**Planning & Urban Development Department**

Project Name: Pamela Road 14-403 Street Extension
Address: Pamela Road
Applicant: Telos Capital
Planner: Nell Donaldson

Project ID: 2014-146
CBLs: 389-D-10, 11, 12, 13, 14
389-E-2, 3, 4, 5, 6, 7

On November 20, 2014, the Planning Authority approved with conditions a Level II site plan for a 750' extension of Pamela Road. The decision is based upon the application, documents and plans as submitted by Telos Capital, LLC and prepared by Northeast Civil Solutions, with revisions dated November 19, 2014. The proposal was reviewed for conformance with the standards of Portland's land use ordinance, including Sections 14-526 (Site Plan) and 14-403 (Street Access).

Drawing Name and Location:
AMENDED SUBDIVISION PLAN
 CRESTVIEW ACRES, PORTLAND, MAINE

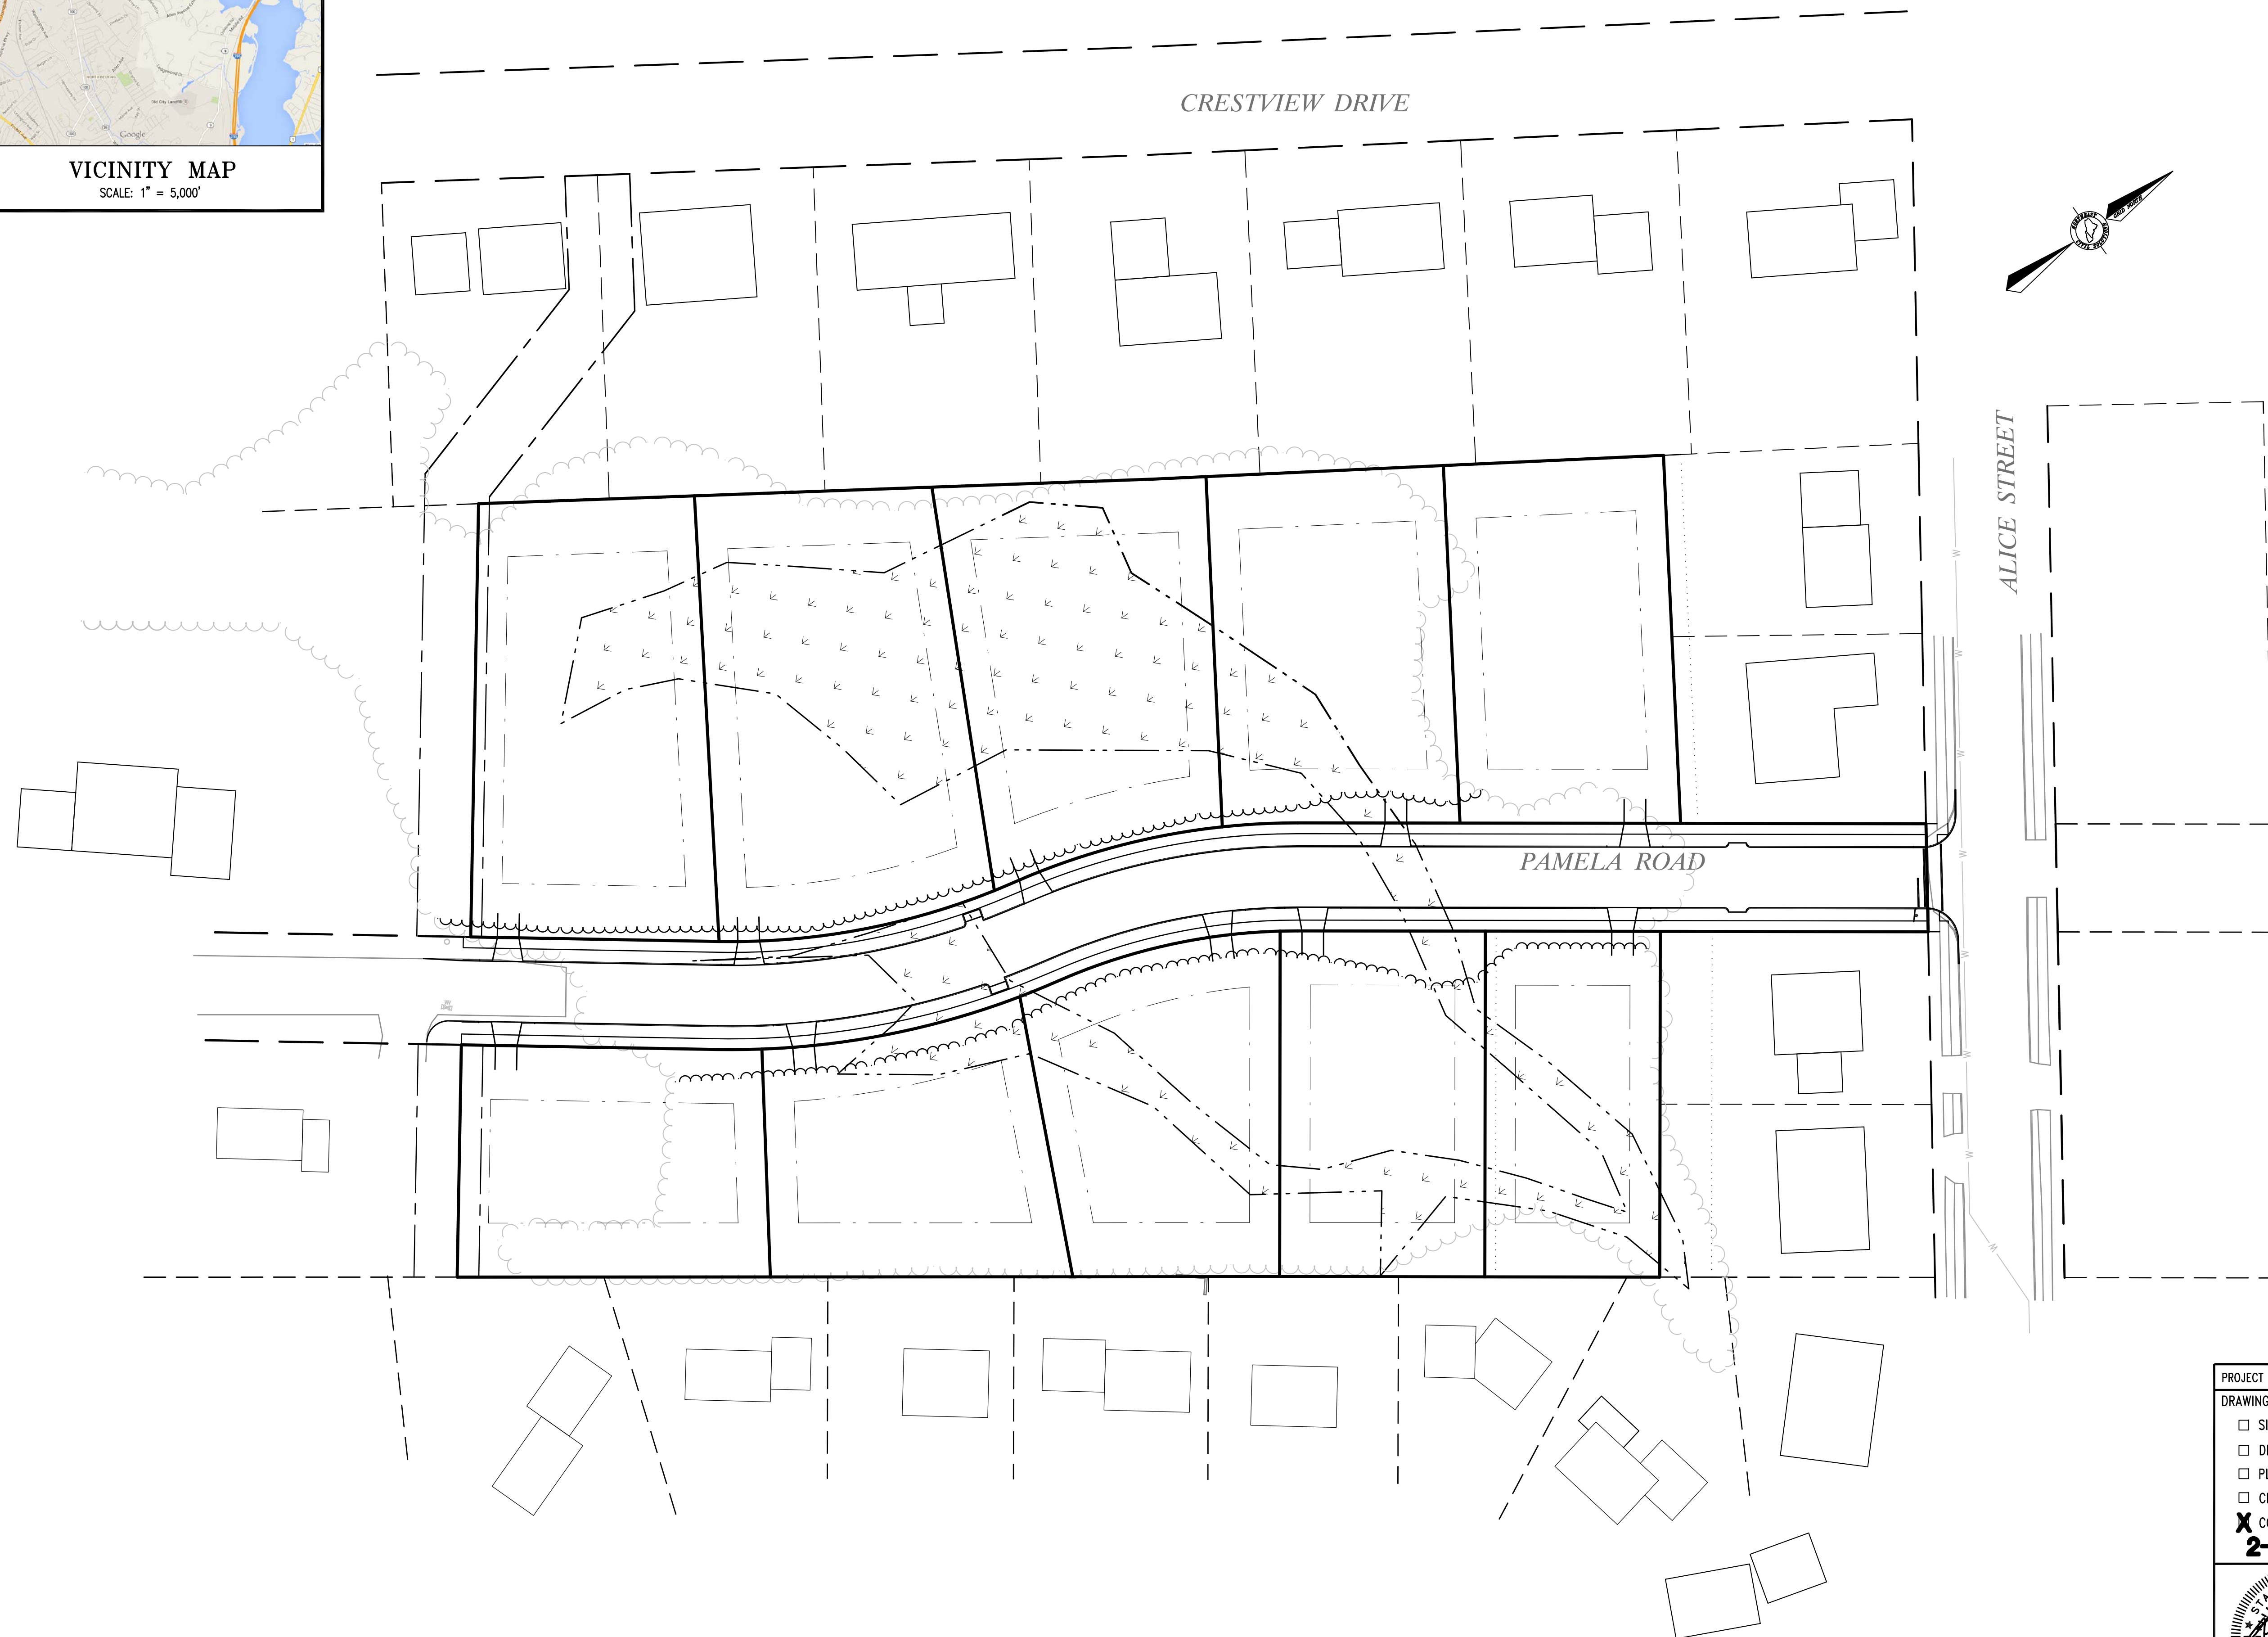
2. The applicant shall add a note to the amended plat stating that:
 - a. the owner of Lot 41 is responsible for drainage infrastructure located on the lot,

- b. drainage infrastructure located on the lot is subject to a maintenance agreement with the City of Portland, and
 - c. the maintenance agreement shall be recorded with the amended plat and be incorporated into the property deed for Lot 41
 for review and approval by the Planning Authority; and
